**DECISION DELEGATED TO DEVELOPMENT MANAGER**

**Application No:** H02-0791-20                      **Applicant:** Mrs J Sadler  
**Proposal:** Erection of new exemplar 4 bed house with swimming pool and gym and separate garage - approved under H02-0968-15. Modification of Condition 2 to allow amendments to previously approved plans (relocation of the passing bay and retention of walls and gates)  
**Location:** Bekstone House 28 Plank Drove Crowland  
**Terminal Date:** 18th November 2020

PASSING PLACE VARIATION

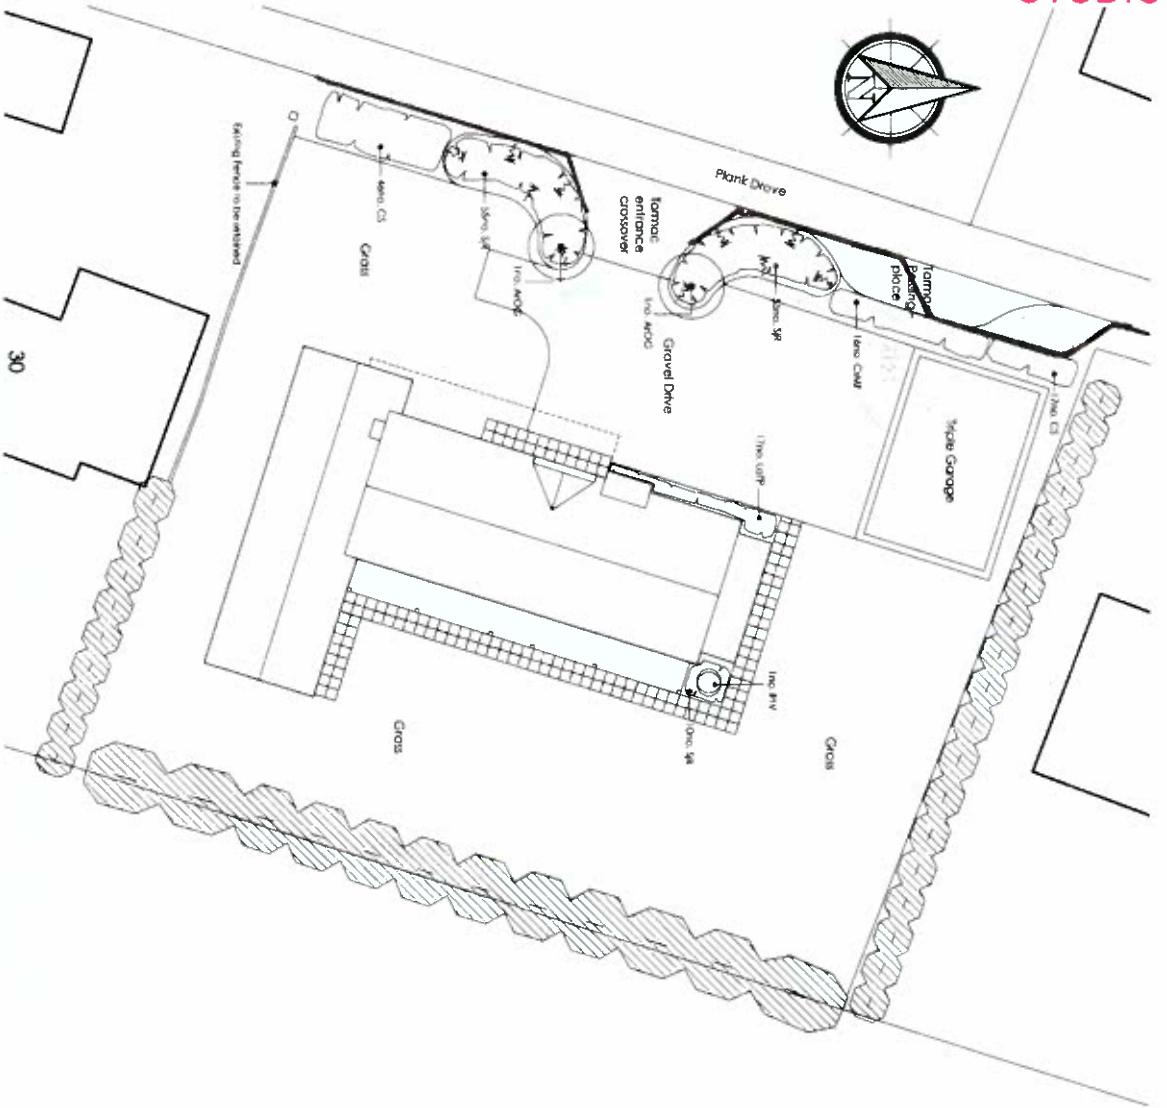
As can be seen from the above, LCC Highway Service has no objection to the resiting and reconfiguration of the passing bay, which was a requirement of the original planning permission granted for the site. It is considered that in terms of highway and pedestrian safety the works are acceptable and accord with Policies 2 and 3 of the SELLP.

The passing bay, which is now bounded by the walls that have been erected, and the wider walls and gates create an urban feel to this part of the drove, however it is not considered that the impact is so detrimental that planning permission should be withheld.

Approve, subject to a condition to seek the completion of the passing bay to an acceptable standard.
